WEST SUSSEX COUNTY COUNCIL CONSULTATION

TO:	Arun District Council FAO: Emma Sheppard
FROM:	WSCC – Highways Authority
DATE:	10 th April 2025
LOCATION:	Land at Oldlands Farm Newlands Road Bognor Regis PO22 9NN
SUBJECT:	BE/16/25/RES Approval of reserved matters following outline consent BE/150/22/OUT comprising of 3 No. units within Class B2 and/or B8 of the Use Classes Order (including ancillary office provision) with associated enabling works, parking, landscaping and sustainable drainage system with access off Newlands Road. This application is in CIL Zone 4 (Zero Rated) as other development.
DATE OF SITE VISIT:	Site known to officer
RECOMMENDATION:	Advice

TITLE:
**SWEPT PATH ANALYSIS -
PROPOSED ACCESSSES**

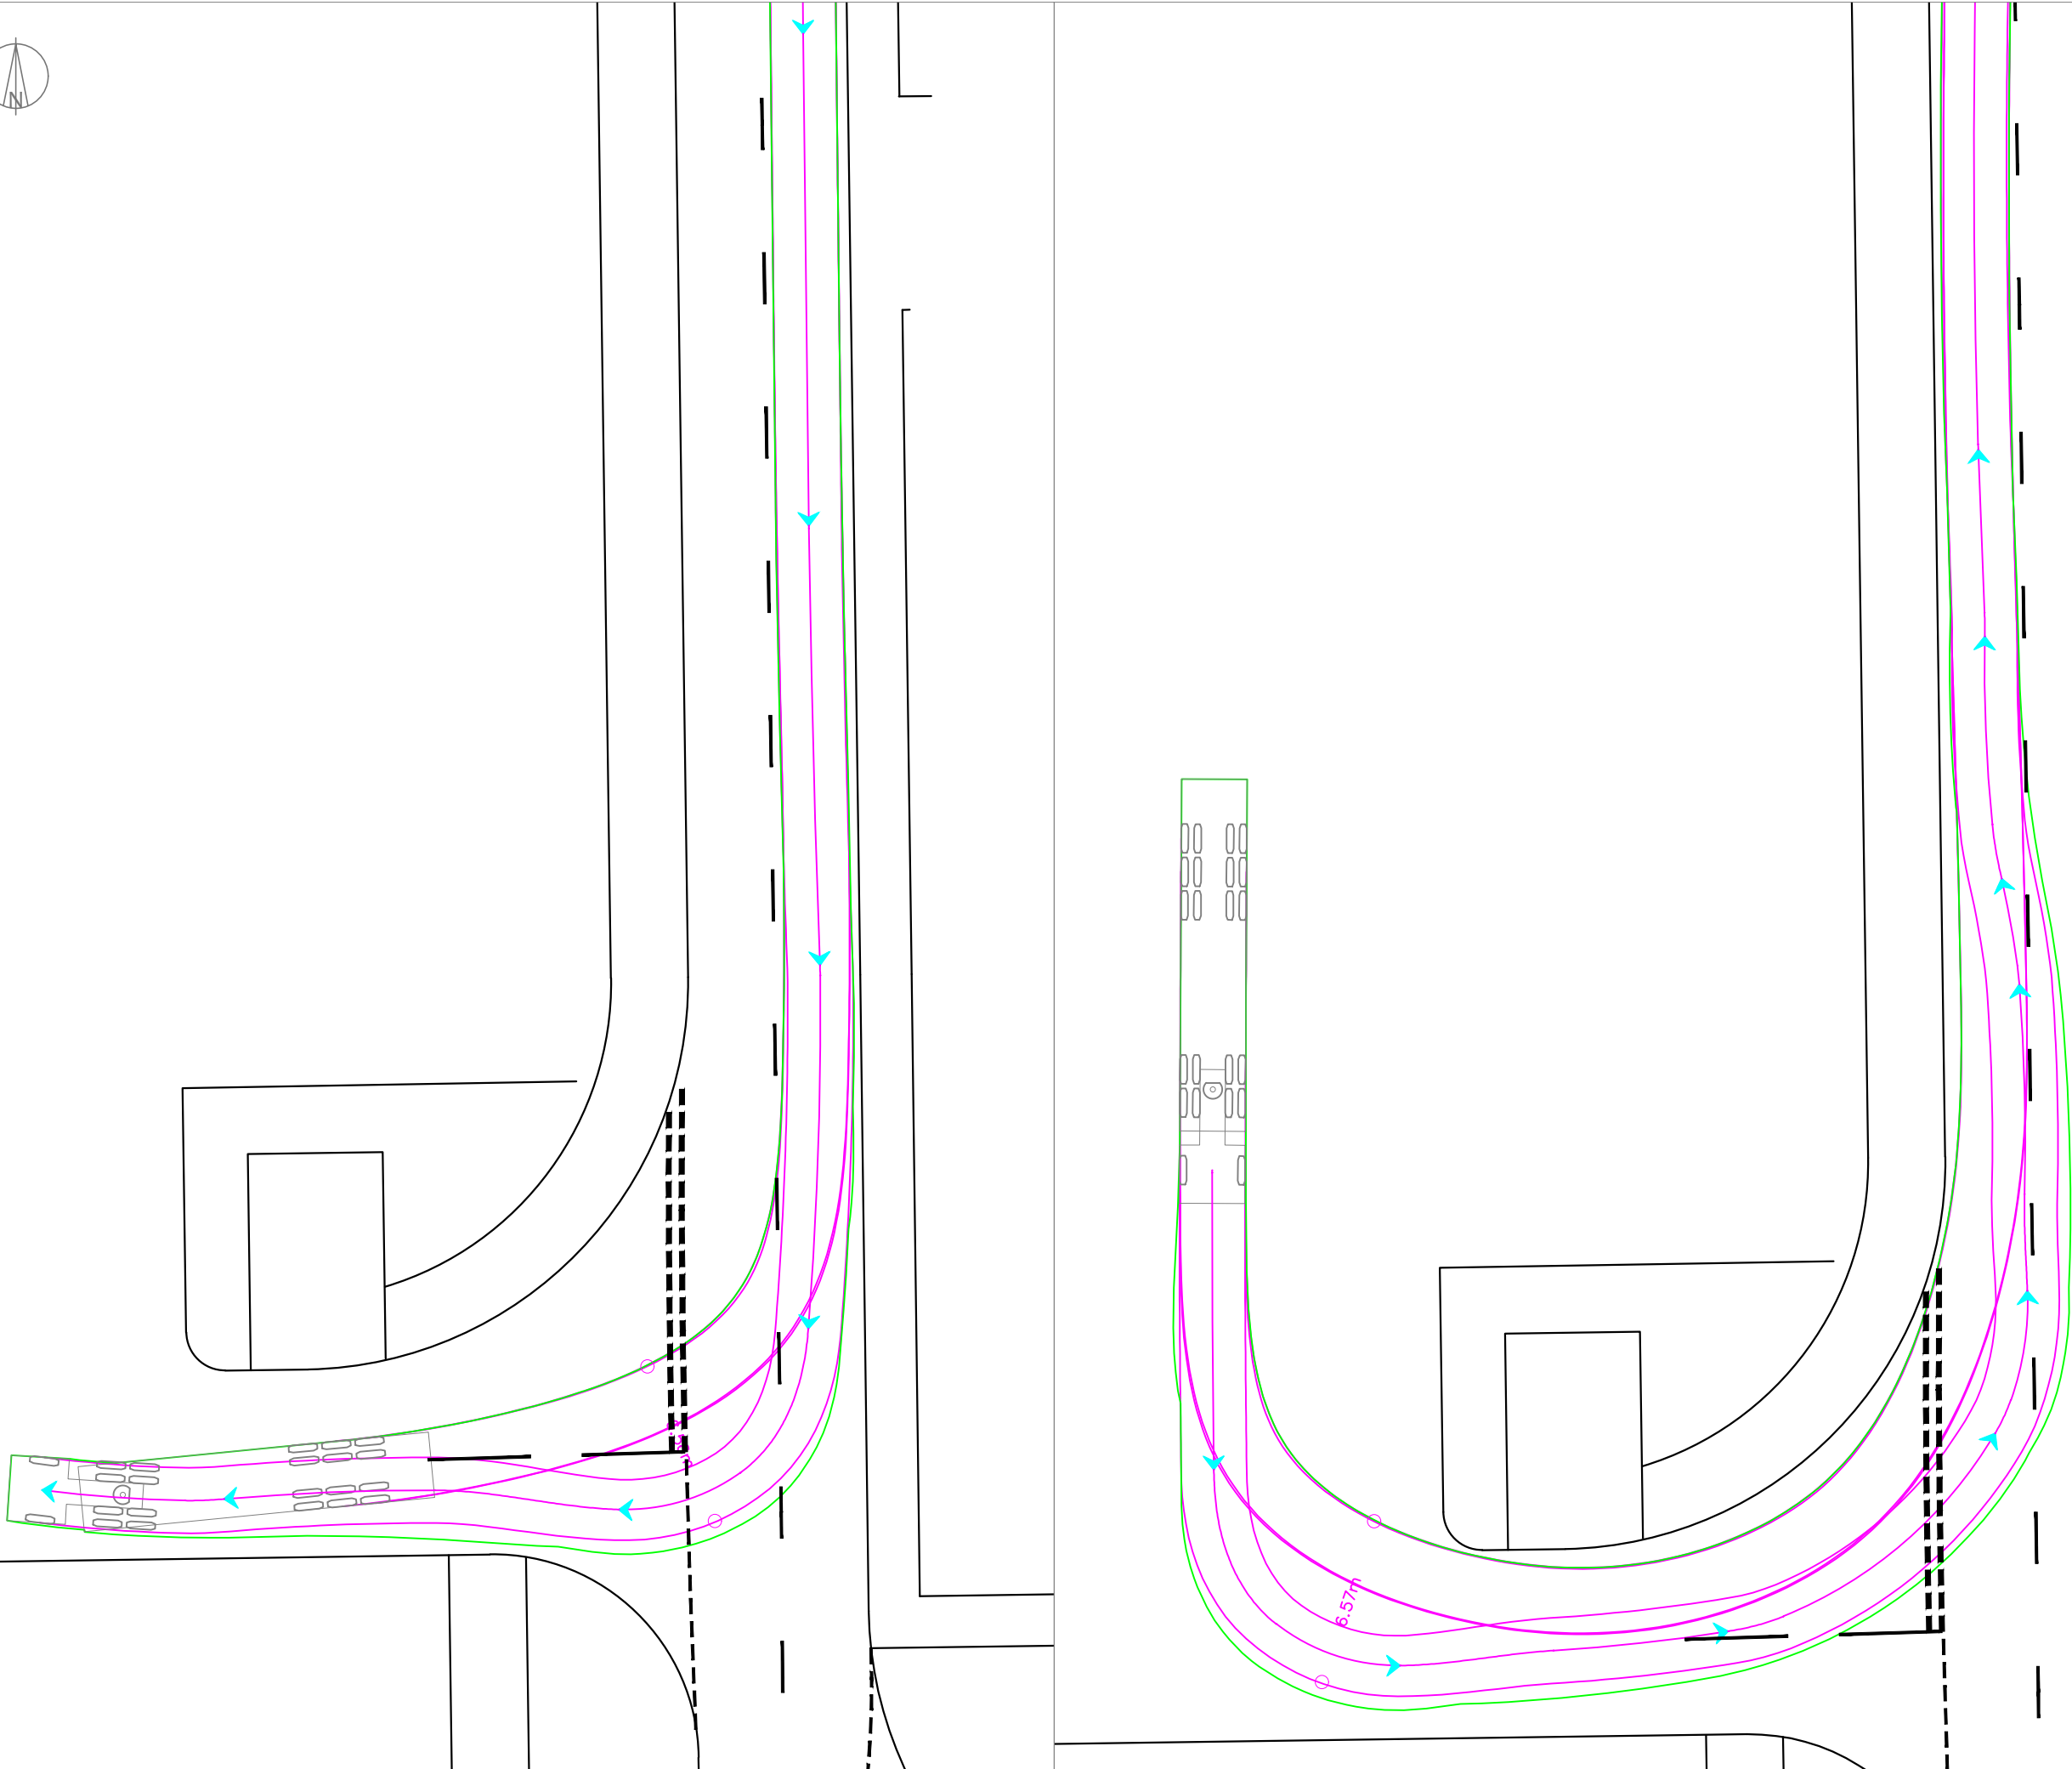
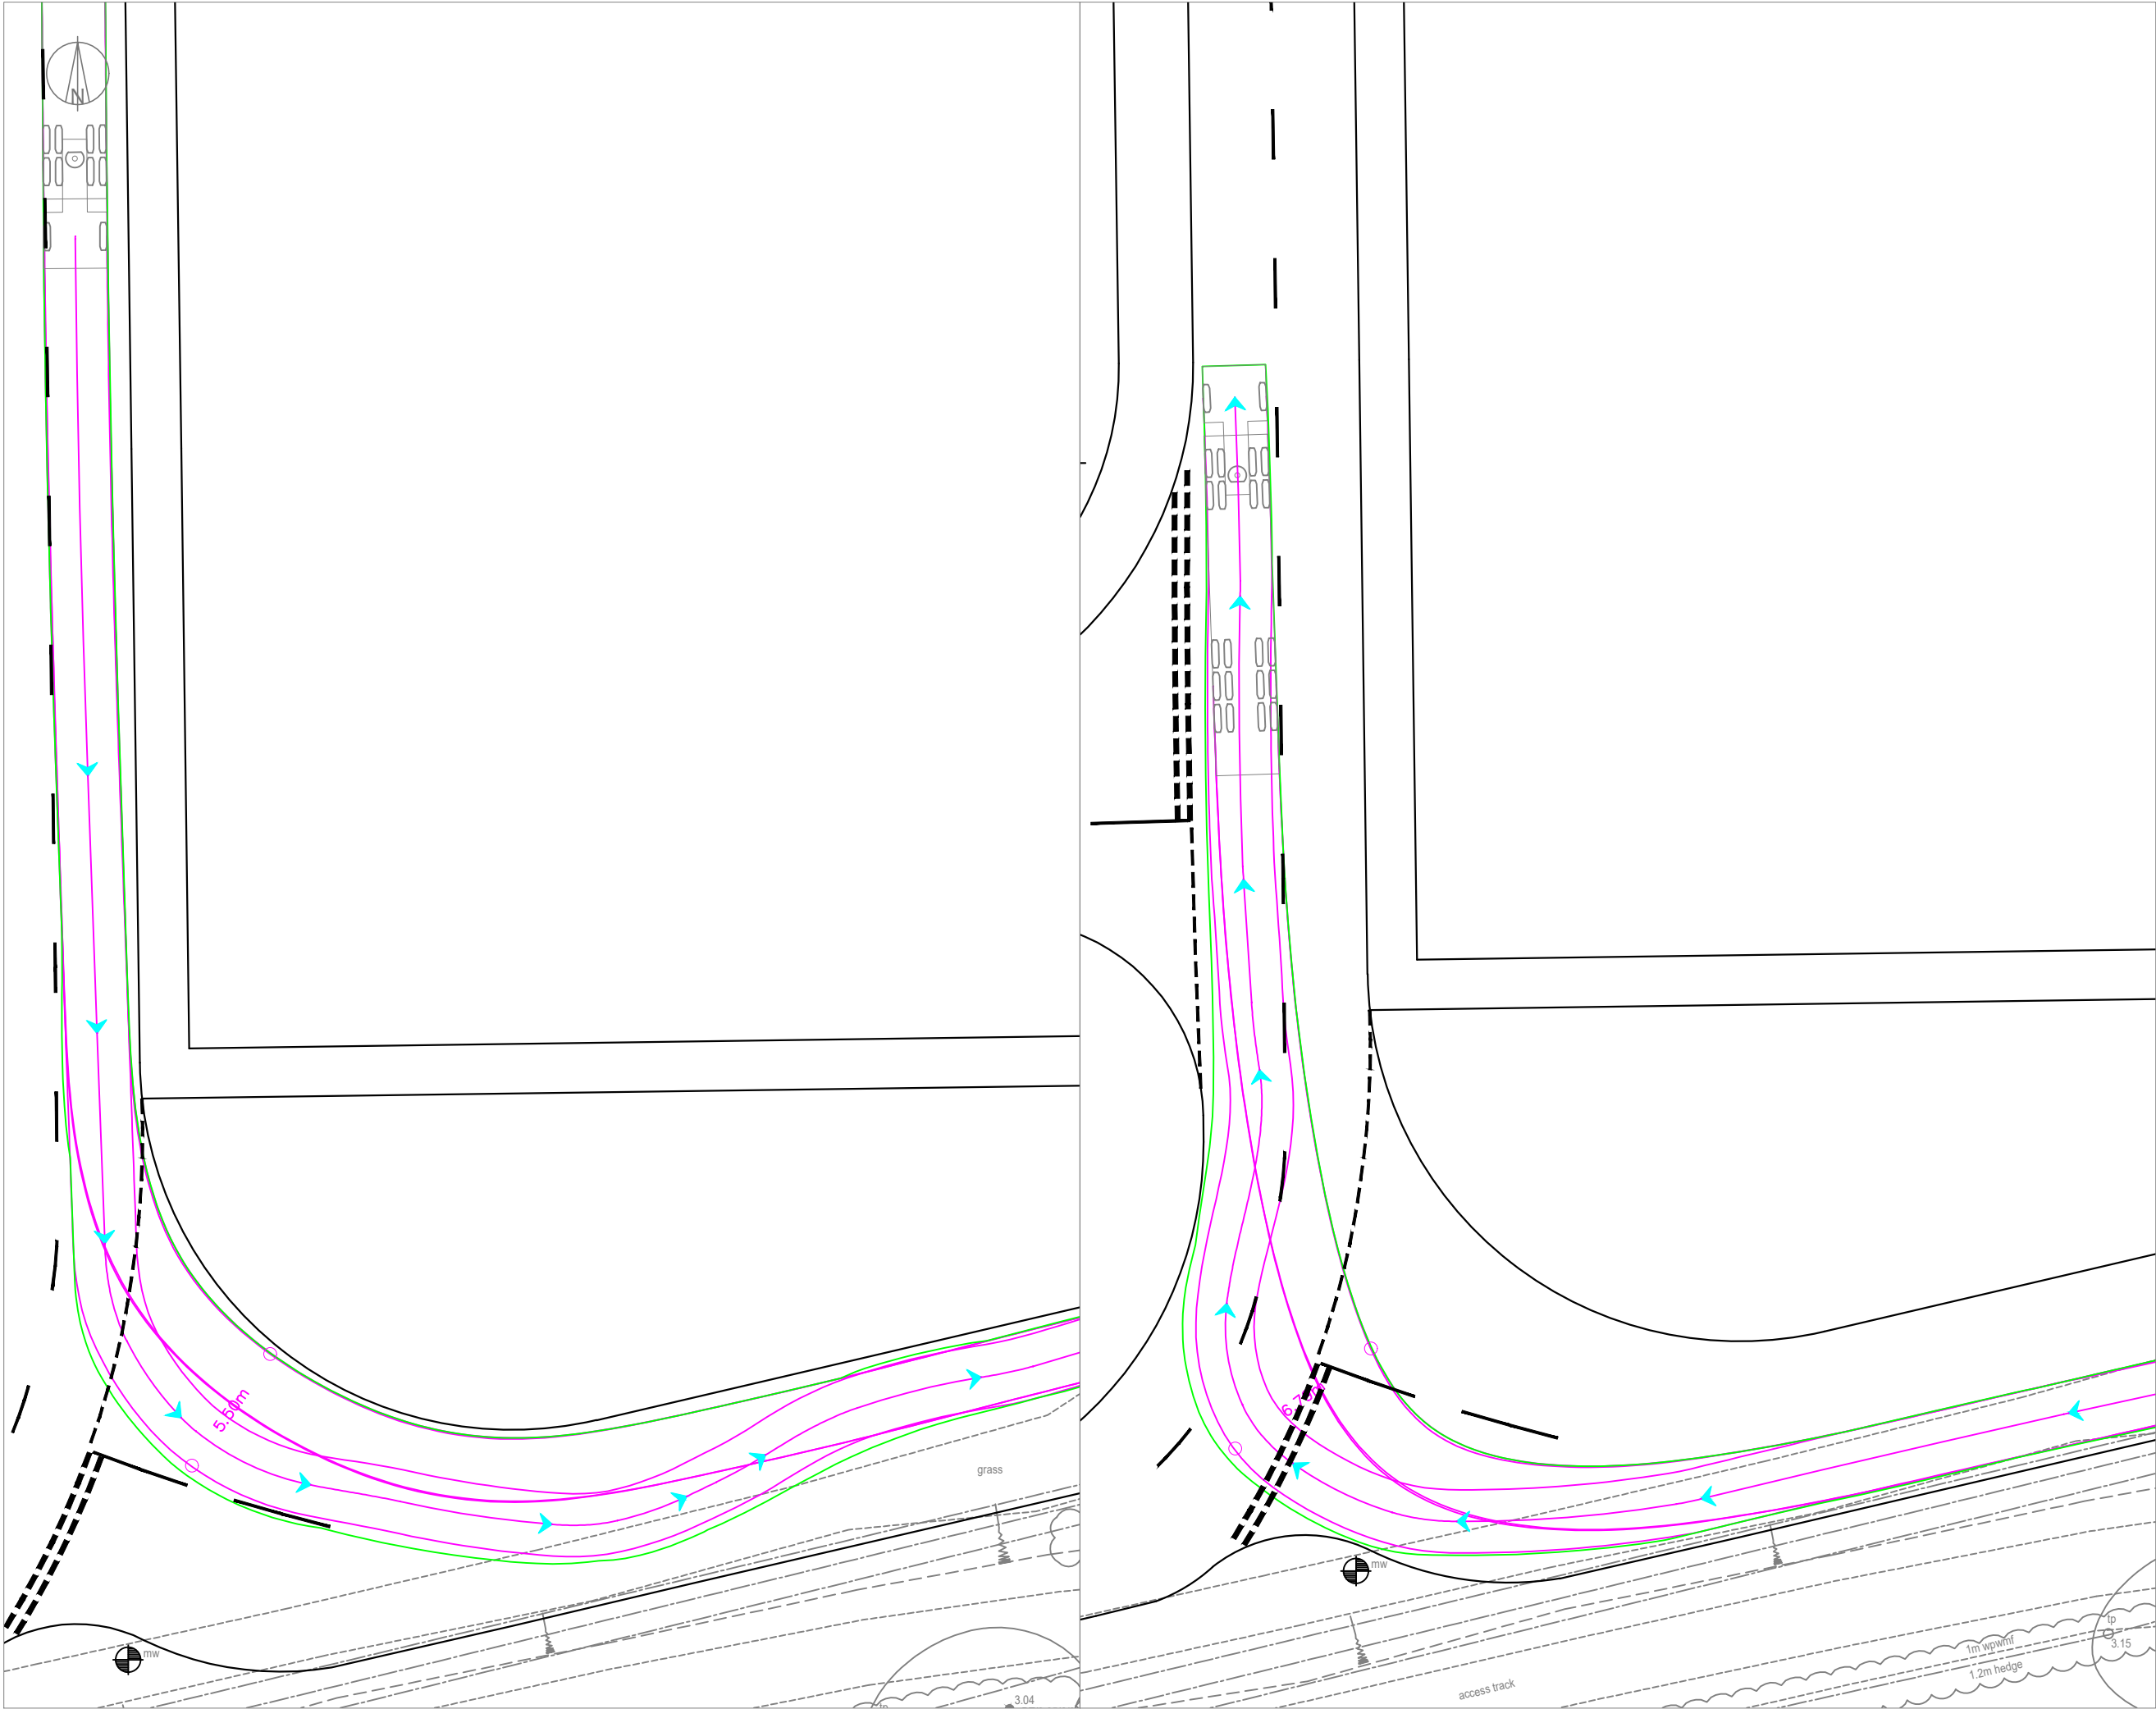
- The revised swept path diagrams do not over run the opposing side of the carriageway, it is noted that the HGV would run over the hatching but it would still be on the correct side of the road. Swept path diagrams have been shown in Appendix 5 of the TN on drawing HTp/24102/TR/03.
